RE – Yass Valley Wind Farm Preferred Project Report response (our ref. 4743)

Thank you for providing the OEH comments regarding this project, addressed to Department of Planning and Infrastructure, dated 29 August 2013.

ISSUES AND APPROACH OVERVIEW

TITLE
 EA & PPR
 Turbine Layout
 Comparison

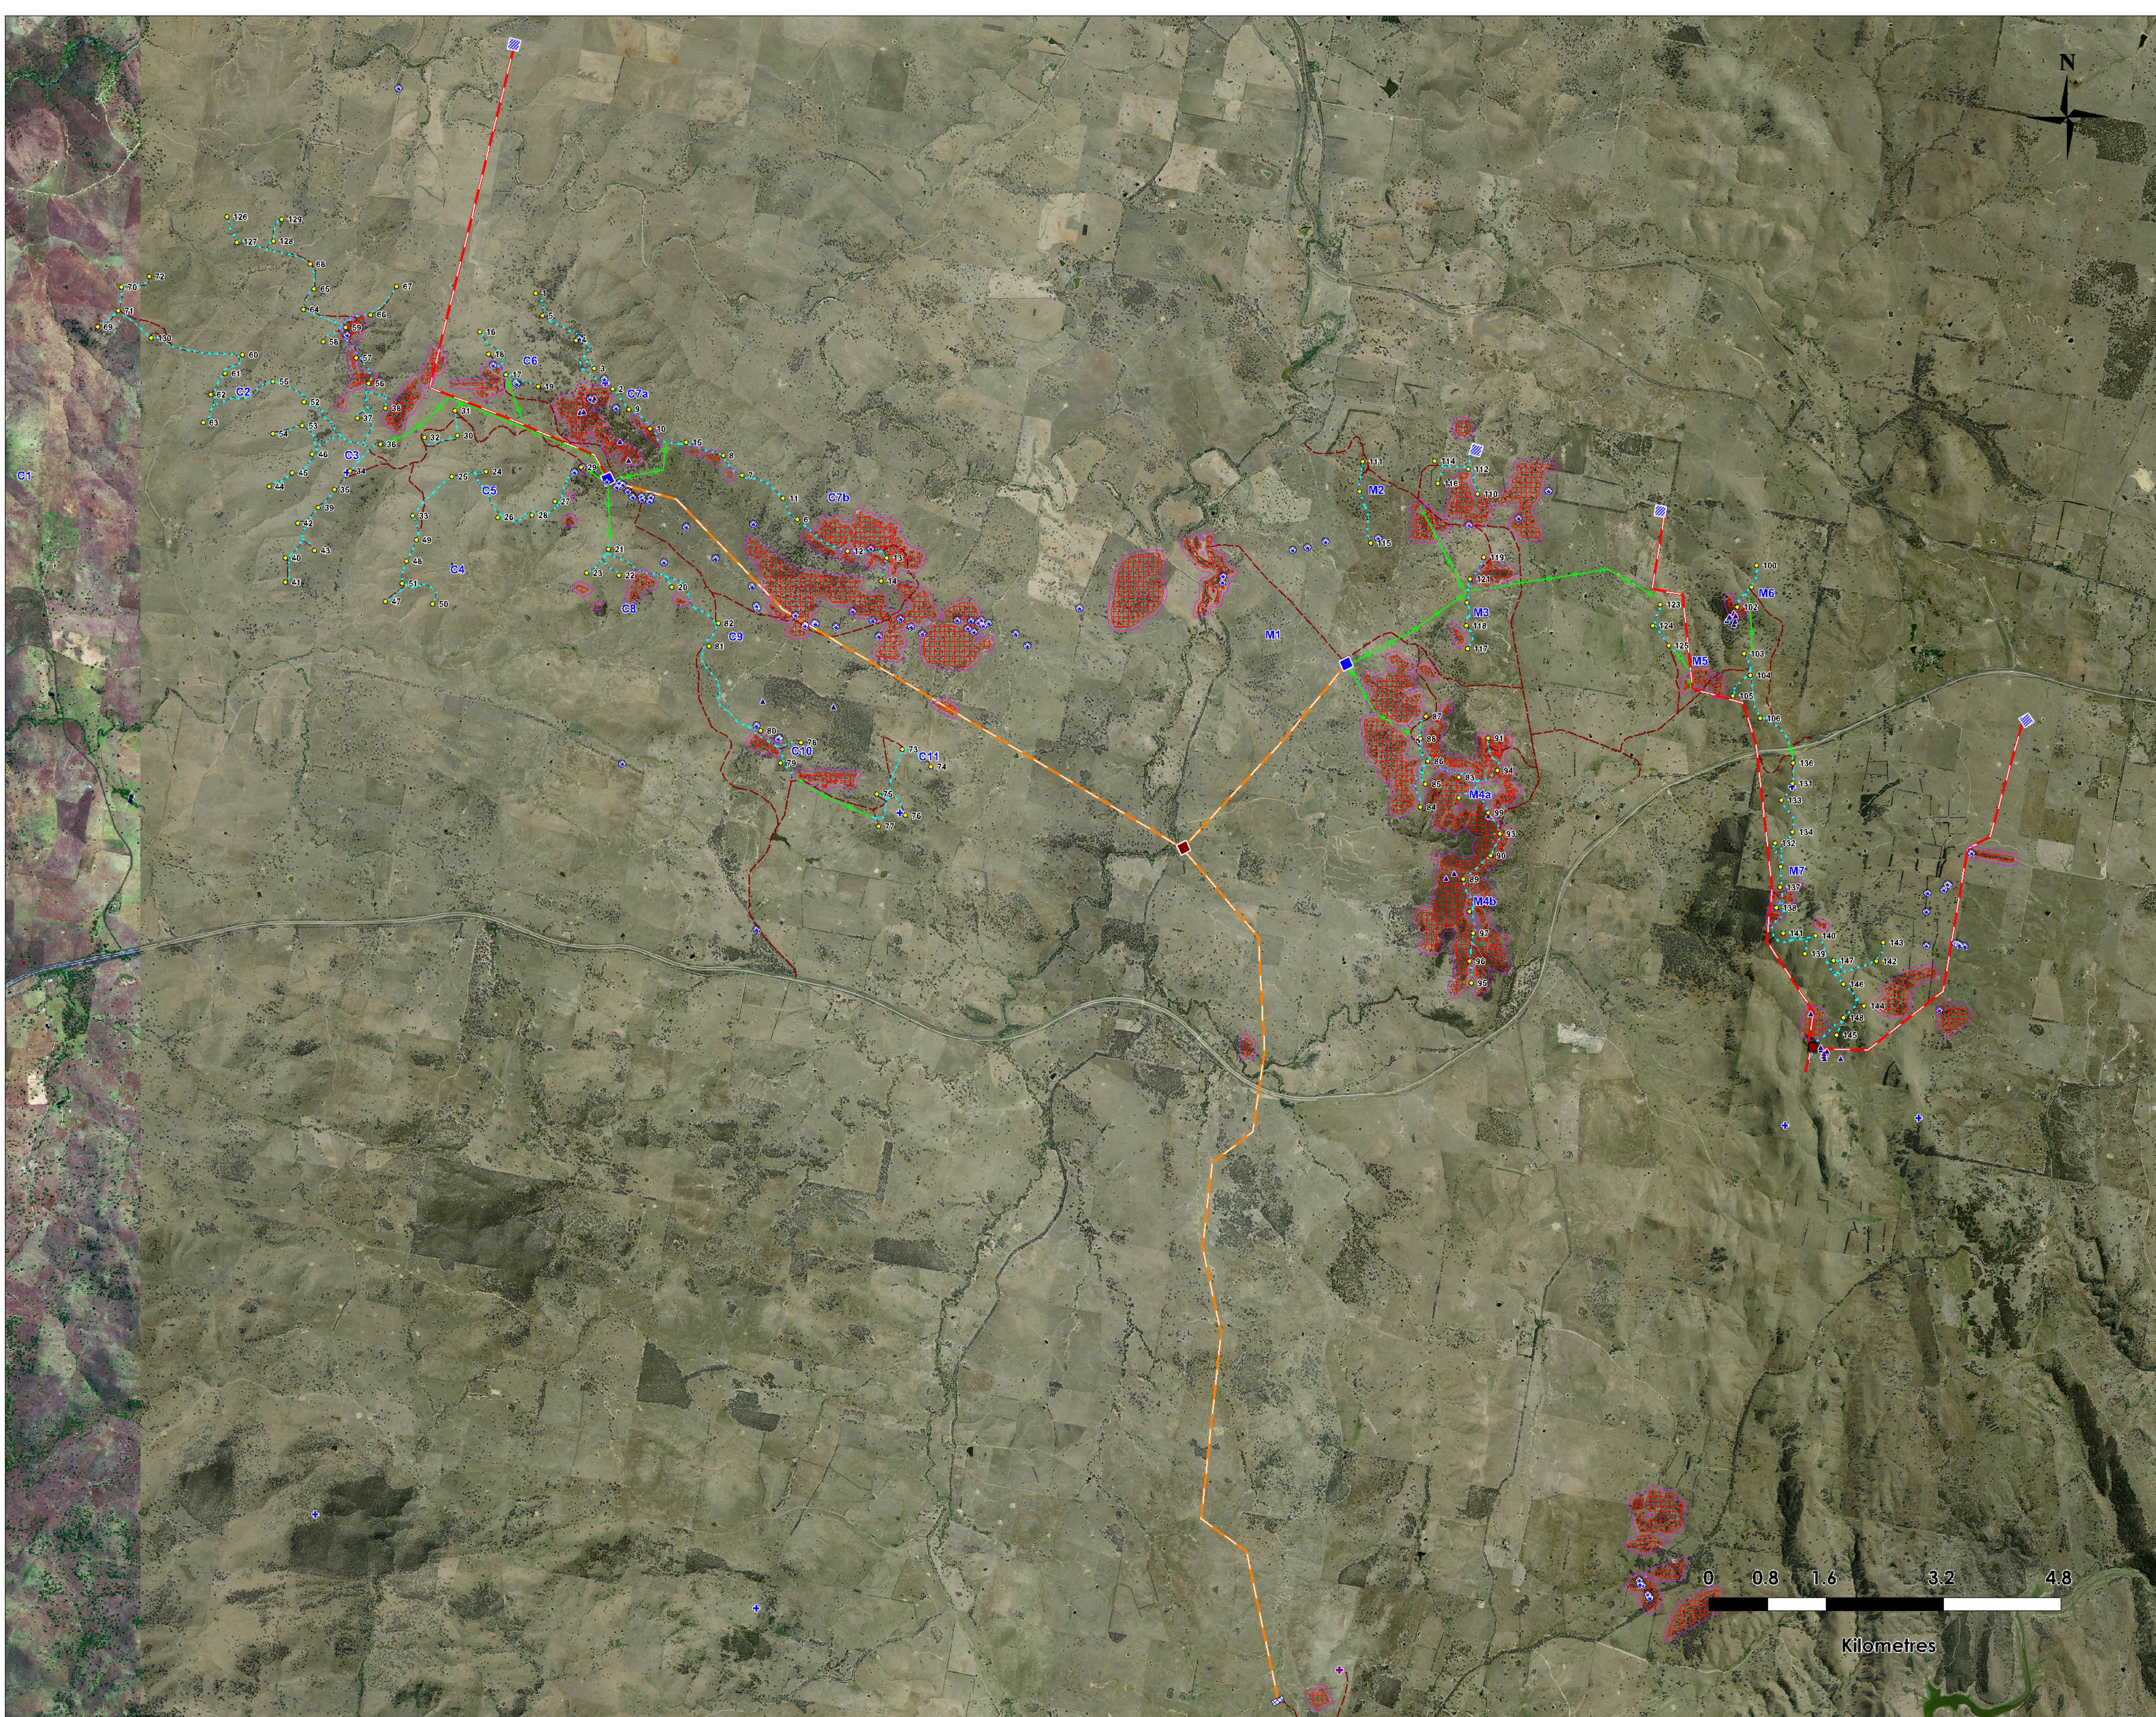
1. Layout comparison EA vs PPR layout, showing changes in turbine layout since the publically exhibited EA.
2. Vegetation types Updated vegetation mapping to show ‘worst case’ clearing estimate of EEC vegetation:
 - Areas of ‘pasture’ and ‘exotic’ vegetation have been moved in to Box Gum Woodland in poor-moderate condition, as a precautionary treatment, in advance of detailed field validation.
 - EEC in ‘moderate to good biometric condition’ has been outlined.

TITLE
Biodiversity
High constraint areas

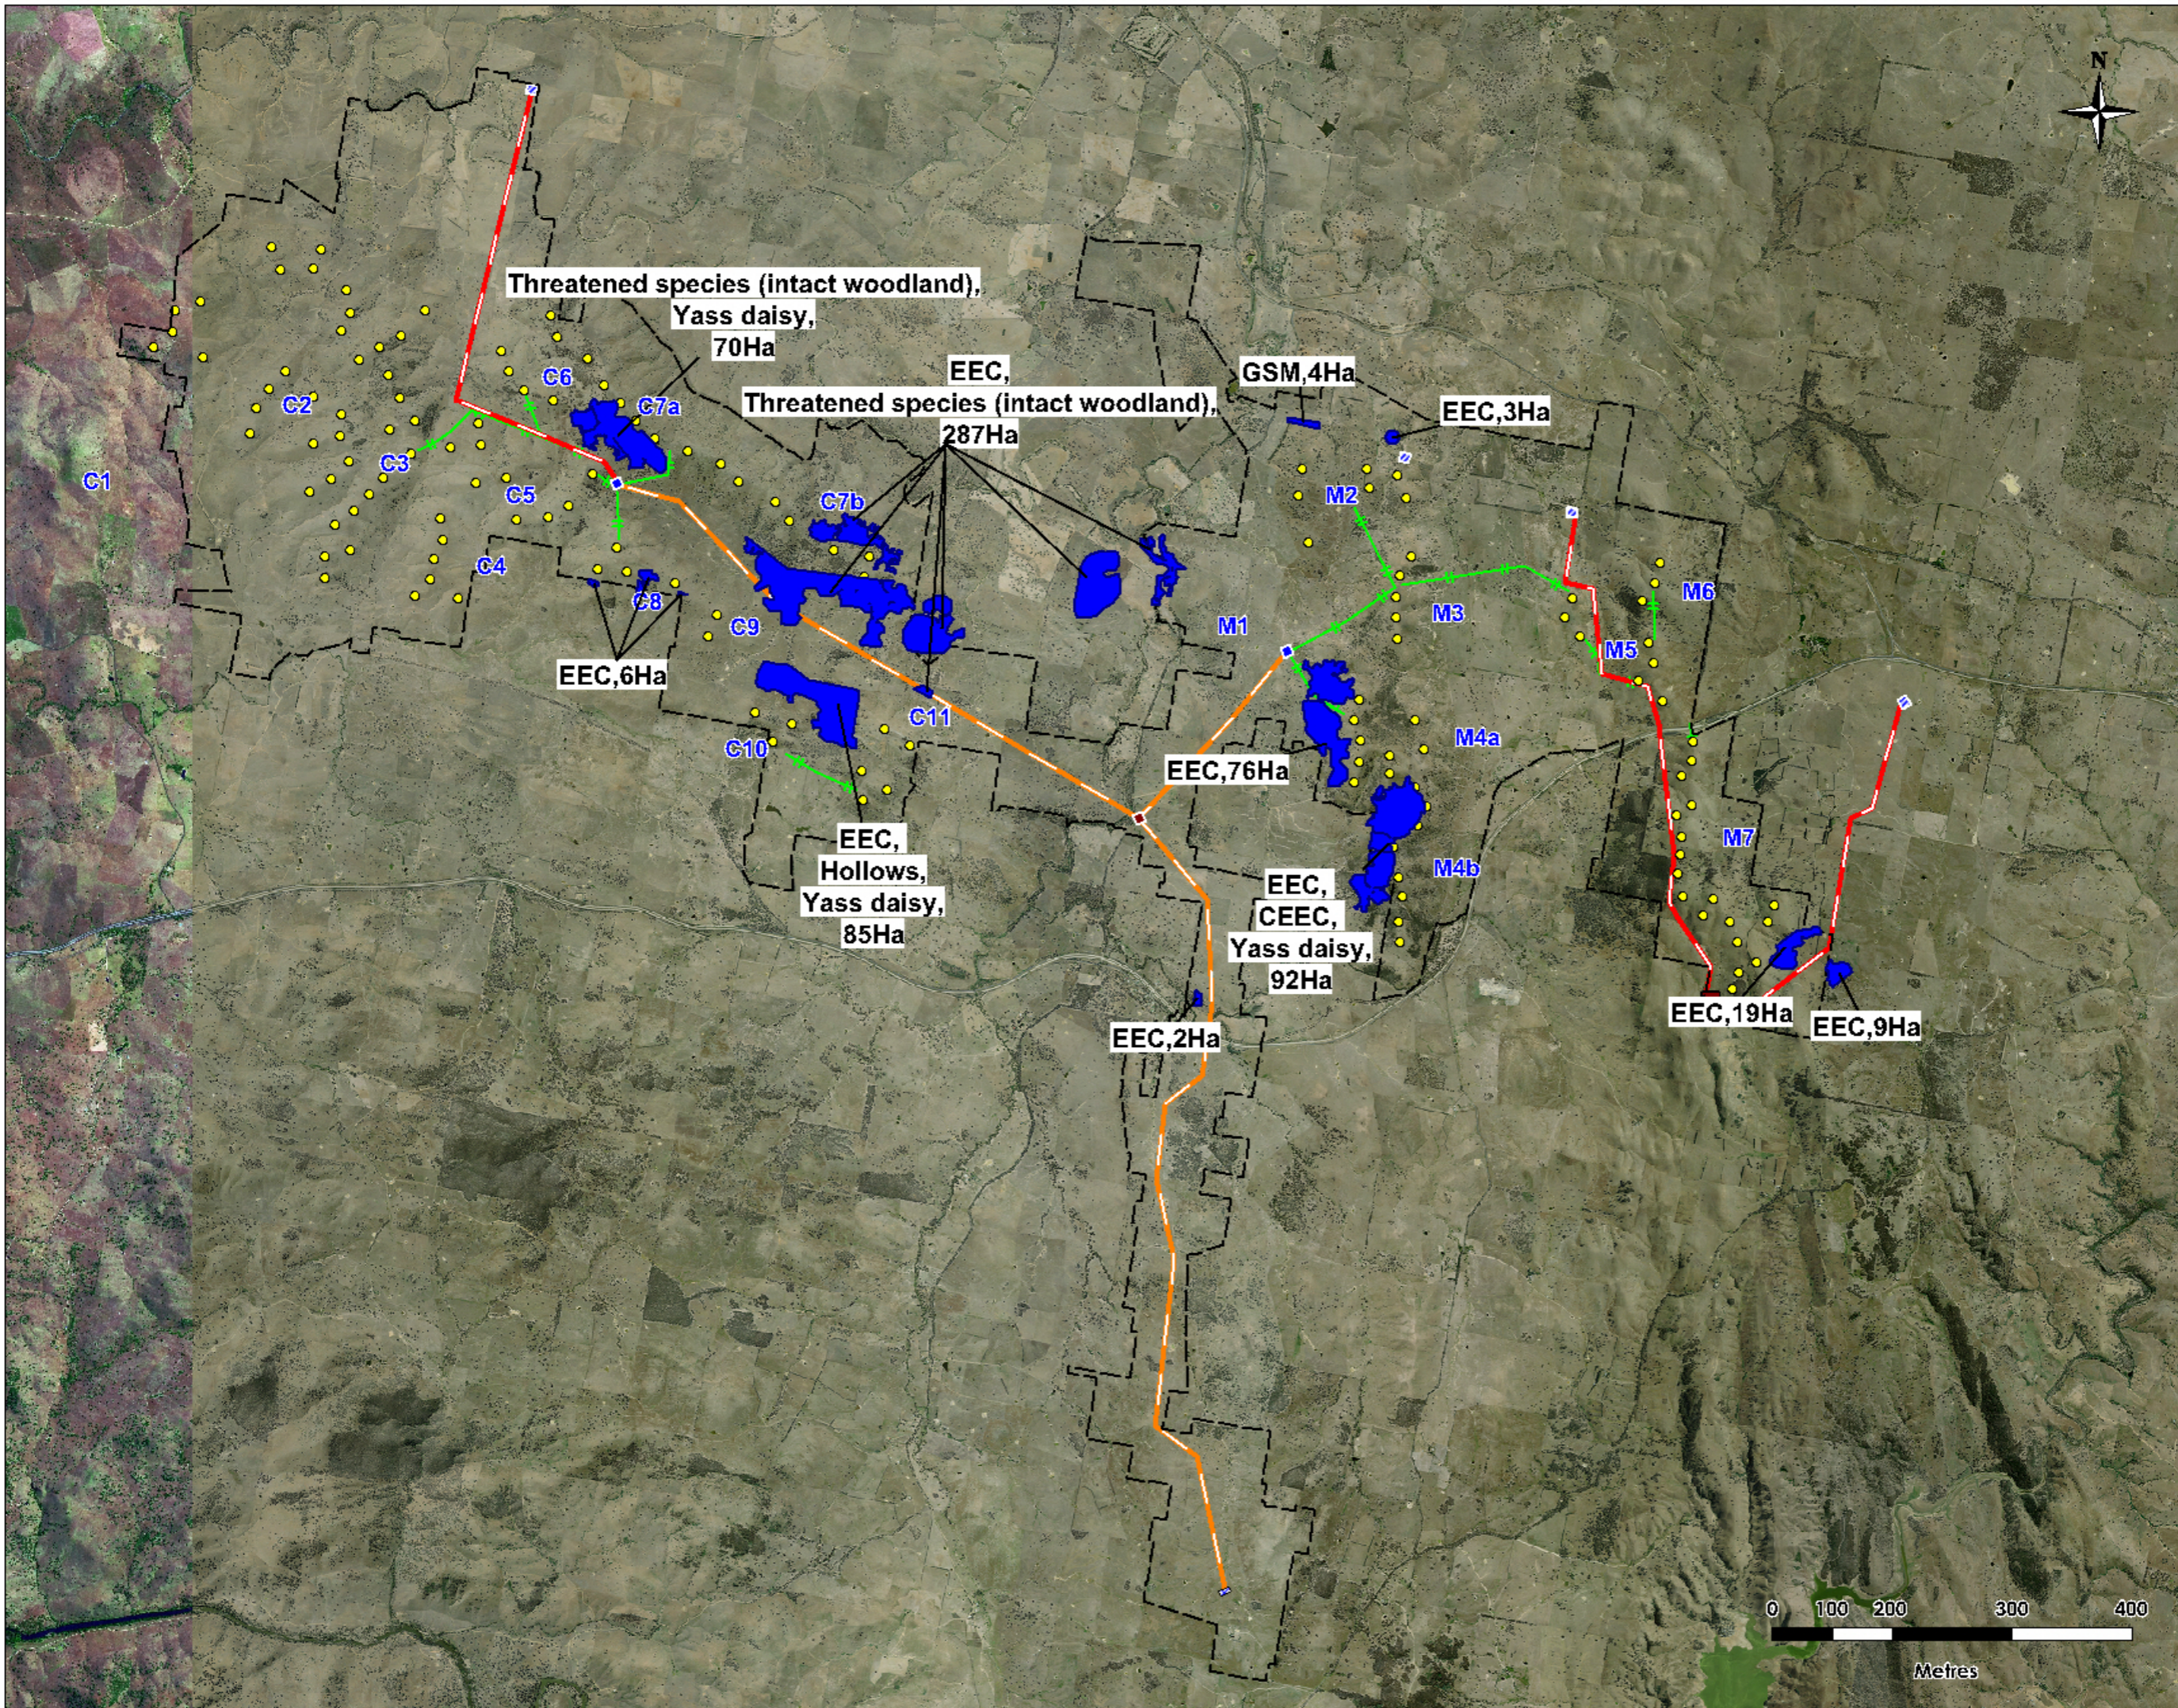
3. High constraint High constraints from the BAs and SER are mapped. This includes:
 - WF site (BAs):
 - EEC in ‘moderate, moderate to good and good’ condition

- Woodland fauna and threatened fauna habitat
 - Marked hollow bearing trees (not exhaustive)
 - TX line (SER):
 - EEC in ‘moderate to good and good’ condition

- Likely movement corridors in woodland and forest
 - Threatened species habitat

- Yass Daisy locations with 5m buffer.

It is noted that the impact of turbines within high constraint areas is not the same as tracks or transmission infrastructure. Some fine scale mapping has been undertaken to allow minimum width tracks in high constraint areas. In these areas, minimising impact on overstorey vegetation can be seen to have been achieved. Where transmission lines occur in high constraint areas, pole footings can be placed either side of the high constraint boundary or in a way that avoids tree clearance.
4. Potential offset sites Potential offset areas include connected mature woodland, EEC and threatened species habitat.
